Recommendation Report for Planning Permission for Works or Extension to a Dwelling

REF NO: AW/208/15/HH

LOCATION: Wide Horizon
11 Waters Edge
Aldwick

PROPOSAL: Ground & first floor rear extensions, balcony & internal alterations

15773/ 02

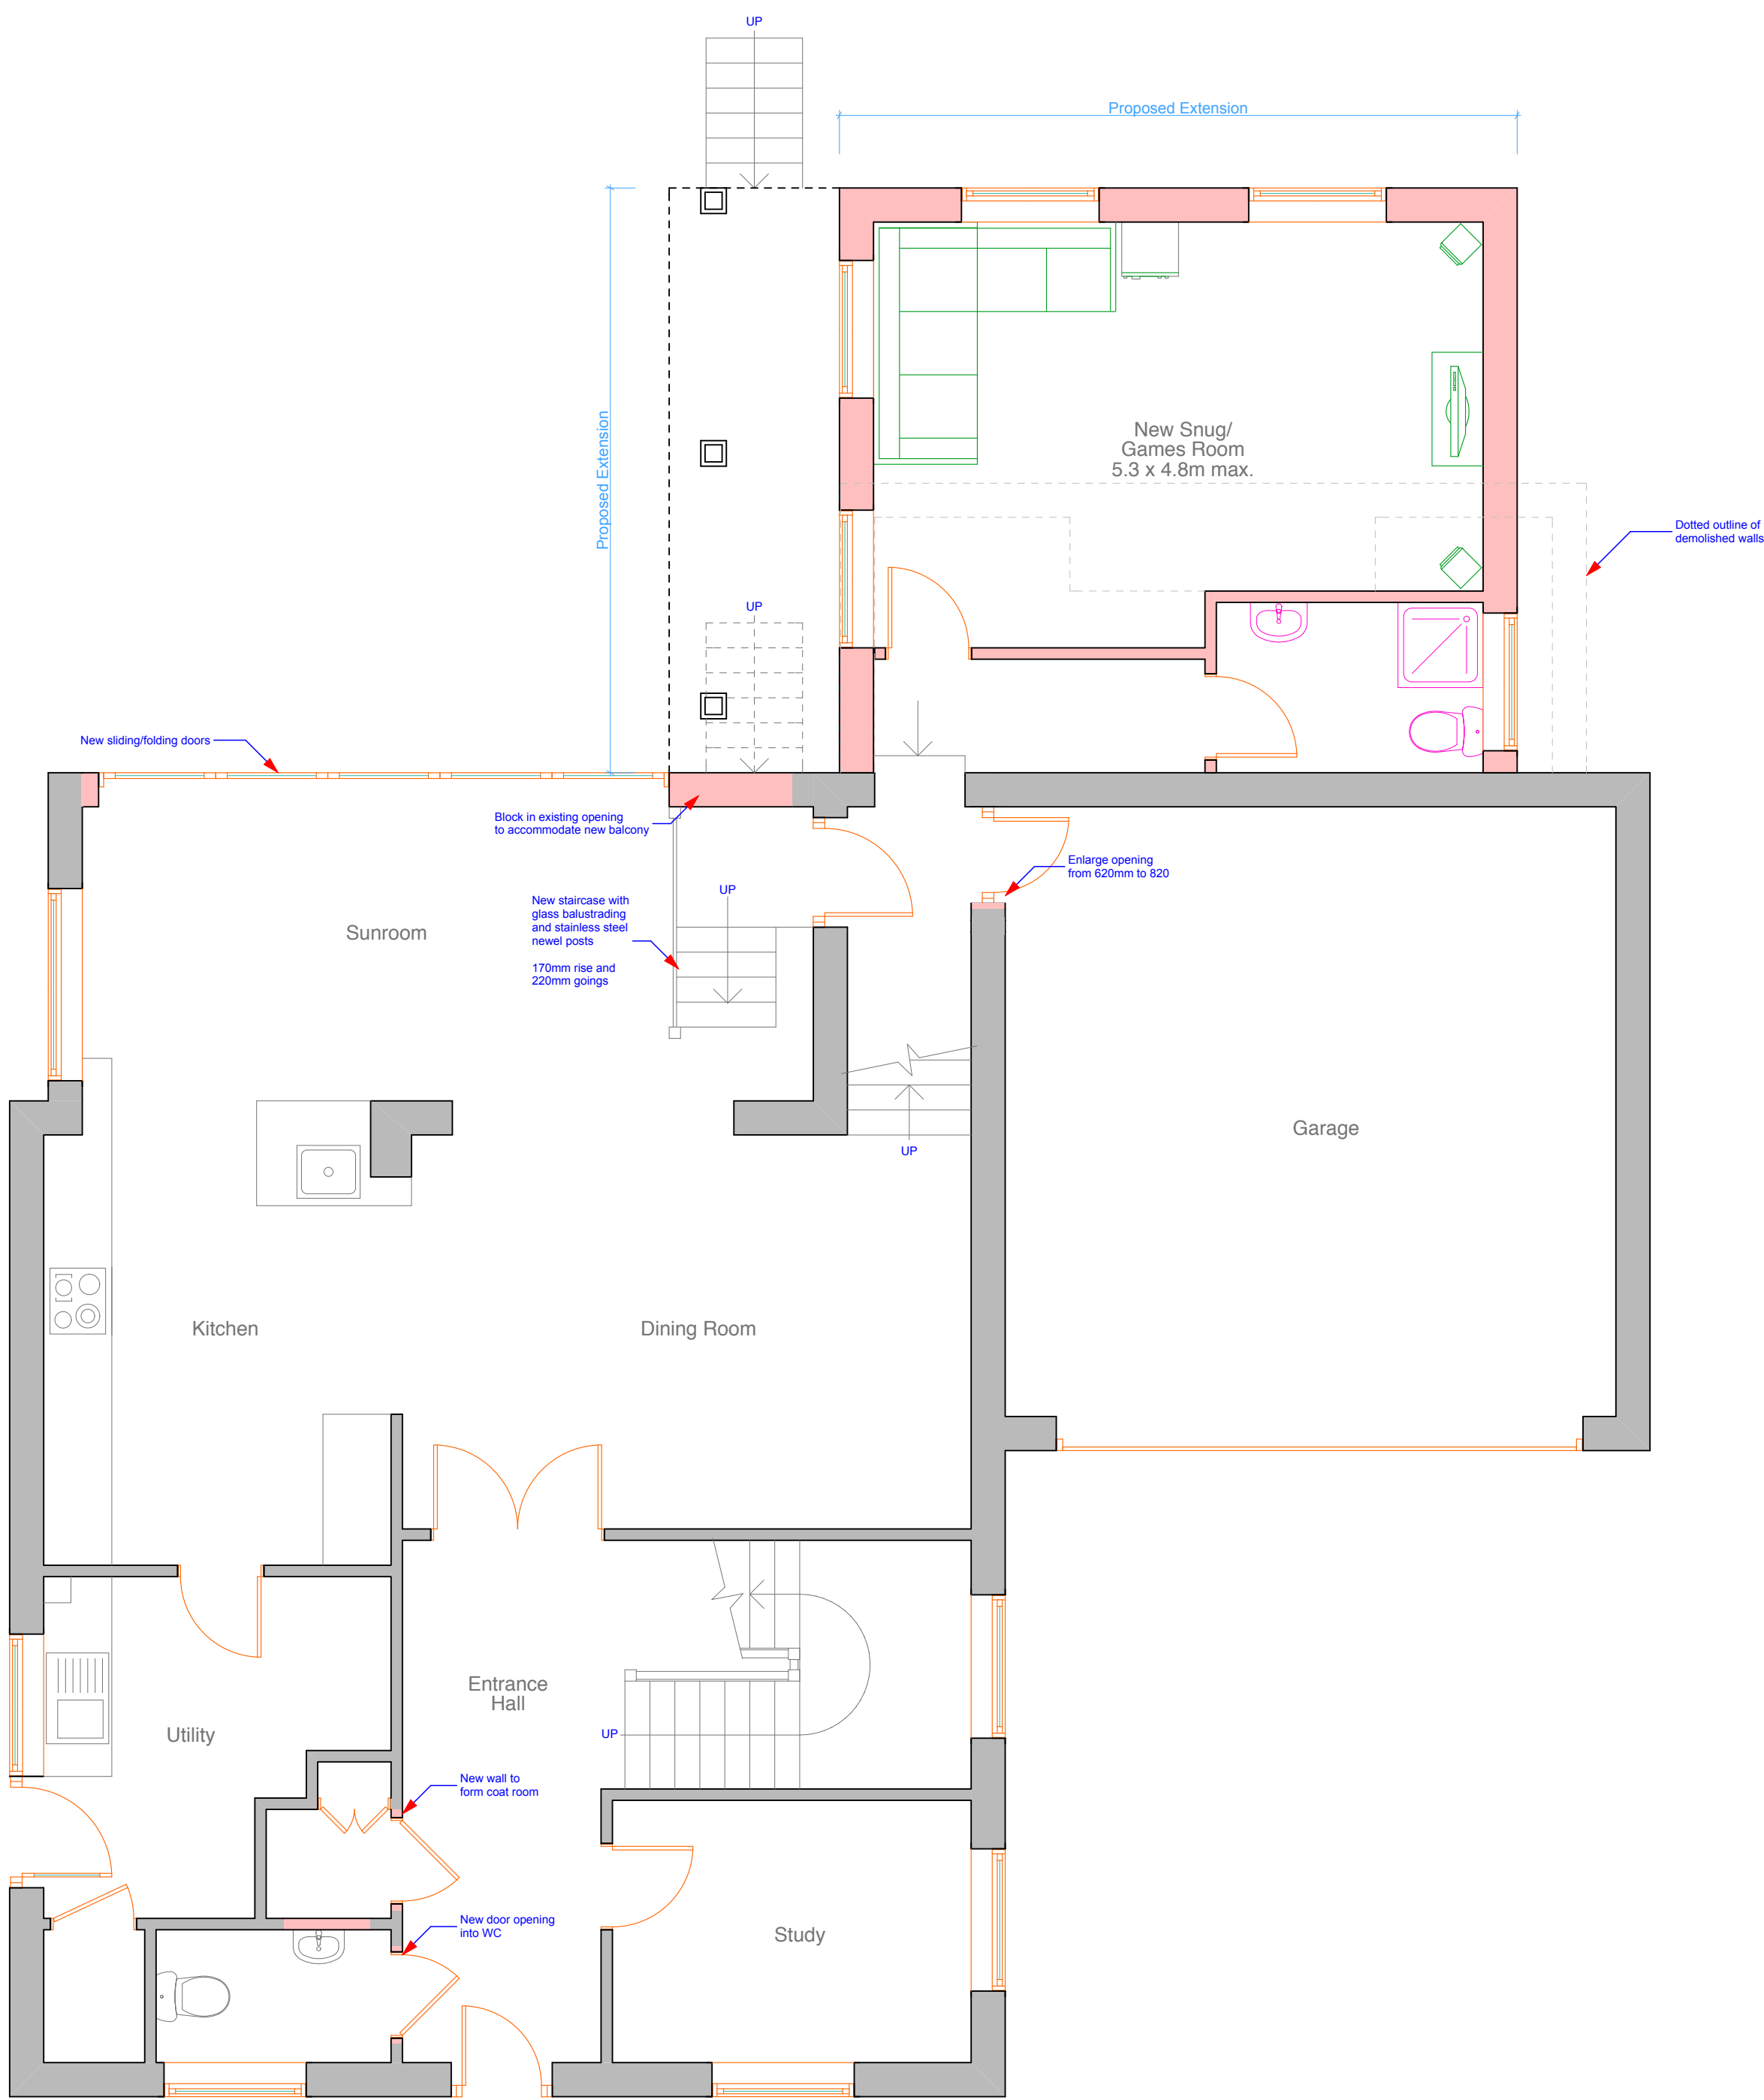
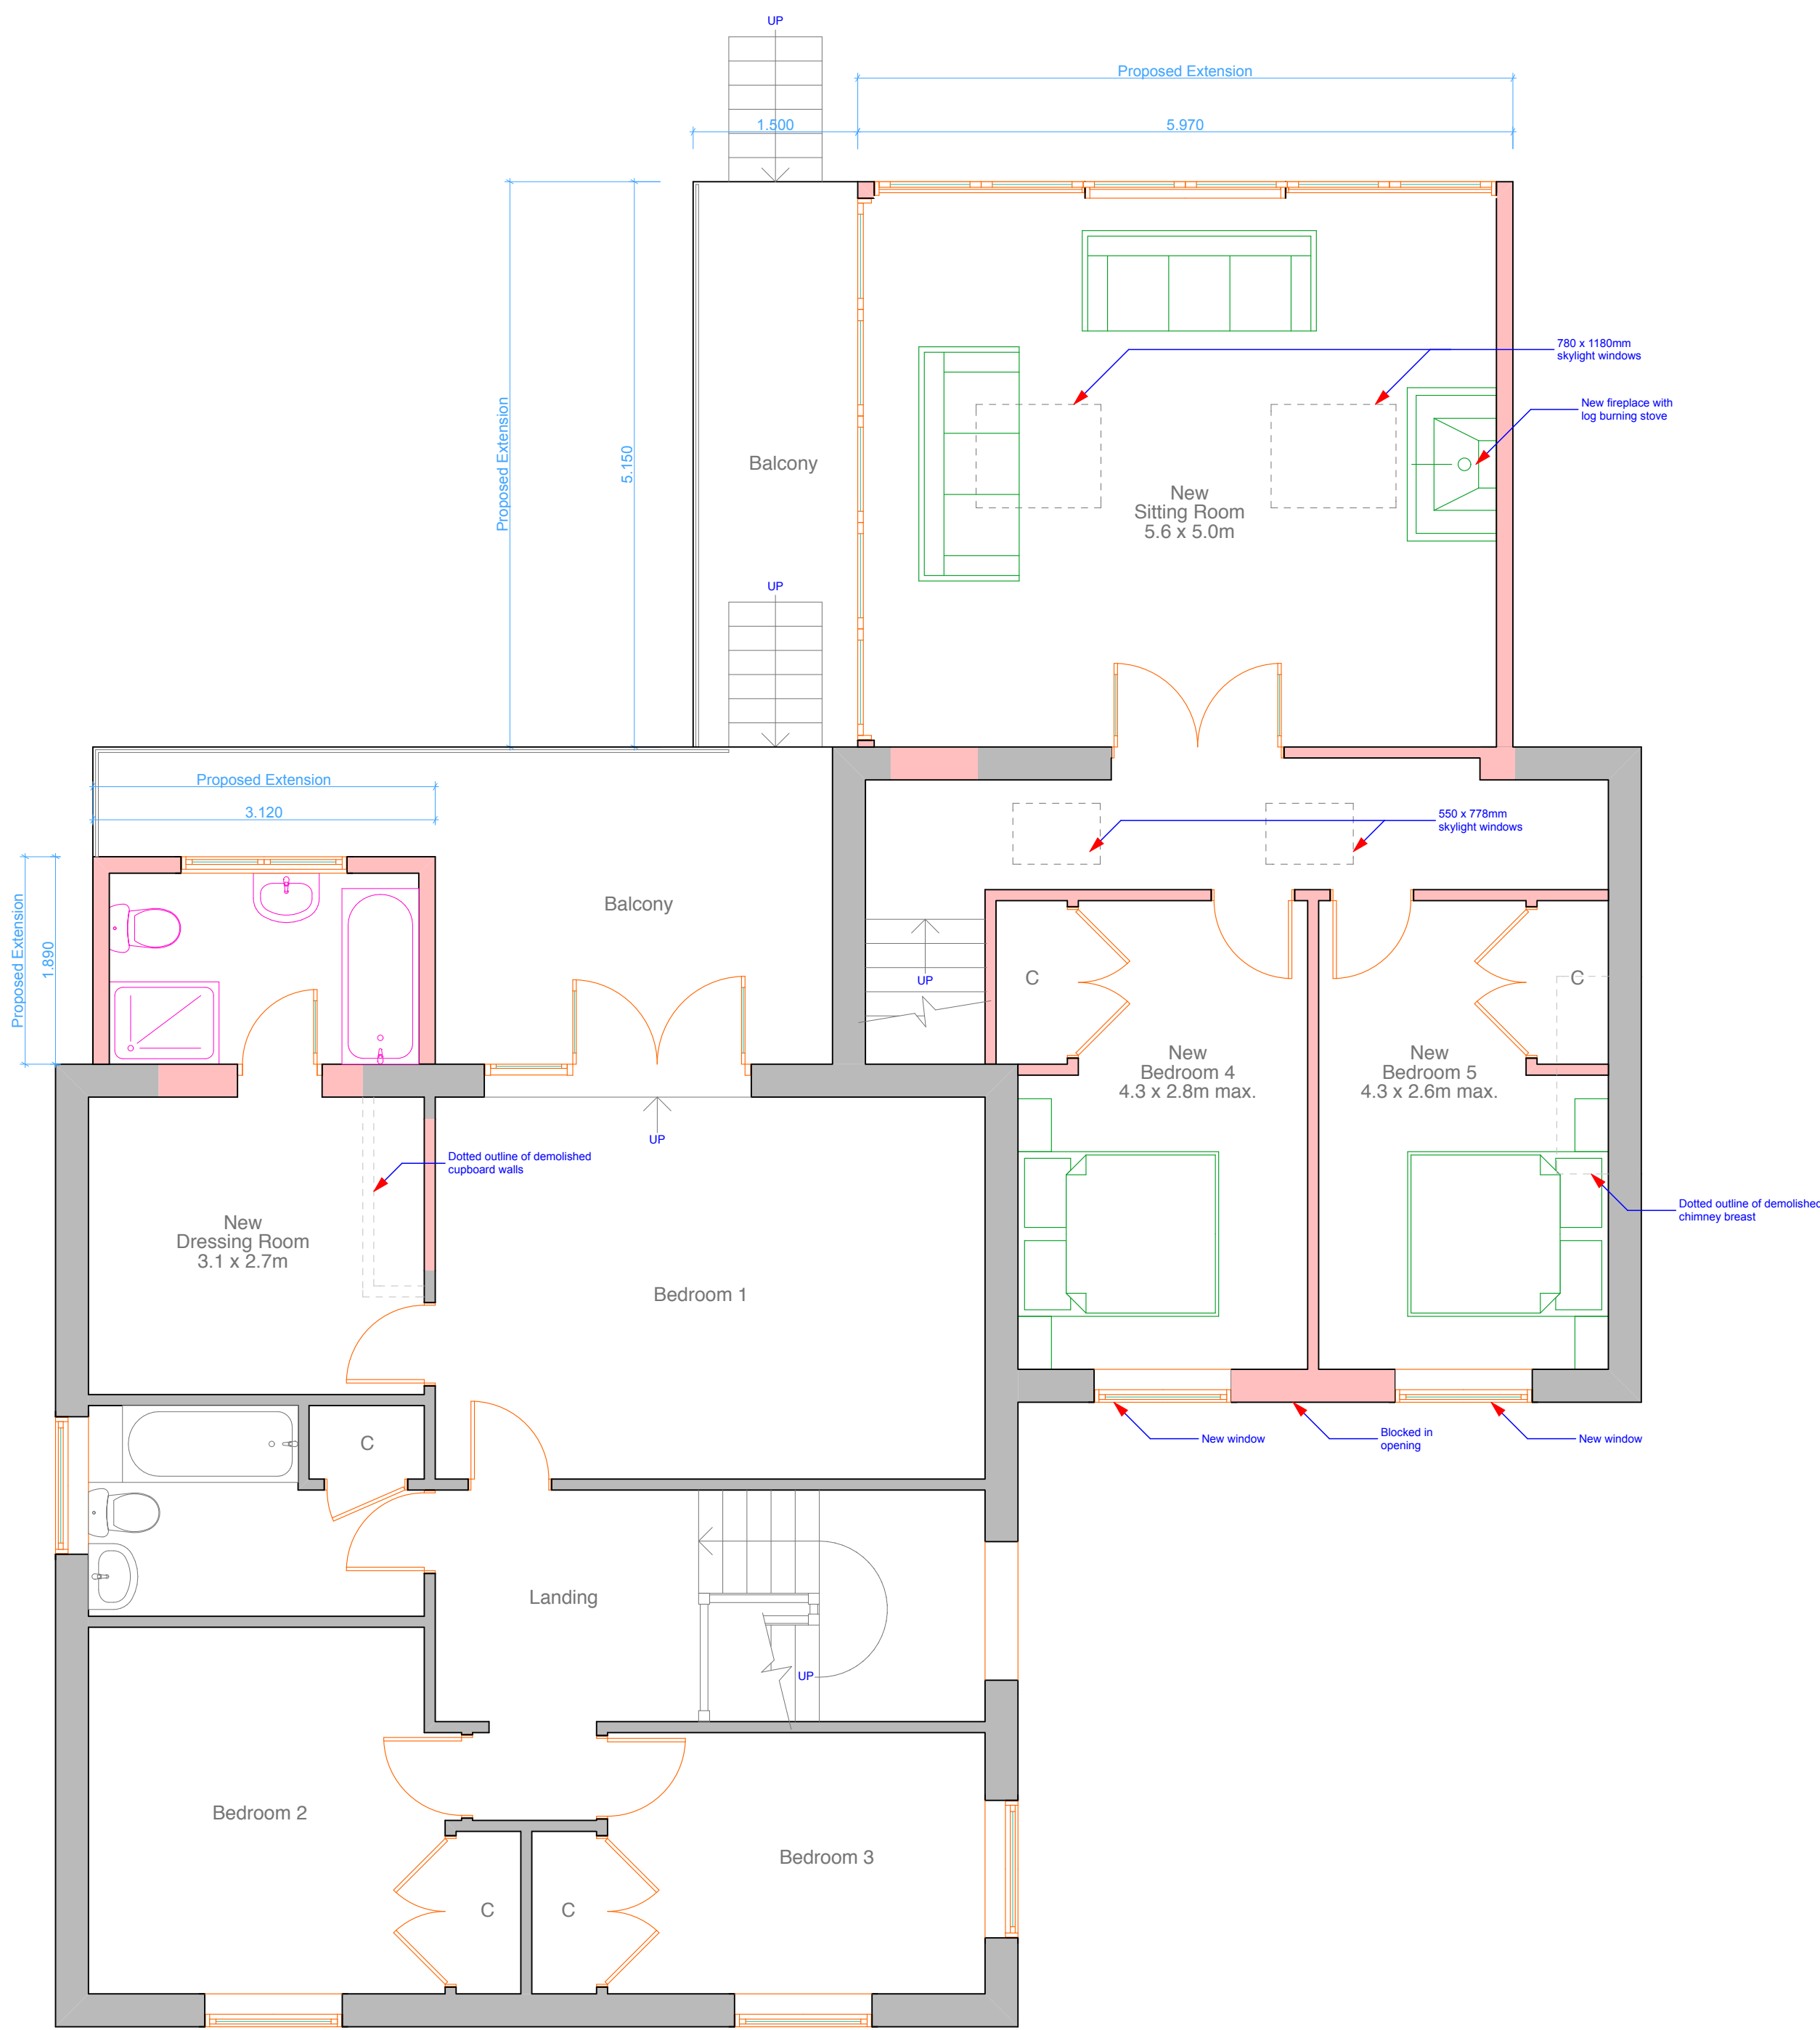
1. Loss of views to the west across 'Aldwick Bay' towards Pagham and Selsey and therefore loss of visual amenity.
2. Loss of privacy to the main rear bedroom resulting from the eastwards facing glazed curtain wall of the extension and glazed balustrade to the balcony serving it.
3. Loss of privacy to the rear garden area of the dwelling to the east.

The application has been revised to include a privacy screen and relocate external stairs from the garden in order to address privacy/overlooking issues.

The extension has been revised to include a 1.7m high obscure glazed privacy screen and stairs from the garden have been relocated in order to avoid there being any openings in this screen which will protect the privacy of the adjoining occupiers garden and views into their rear bedroom. The revised scheme does not give rise to privacy loss and does not result in detriment to residential amenity. Other elevations of the extensions do not give rise to the potential for privacy loss.
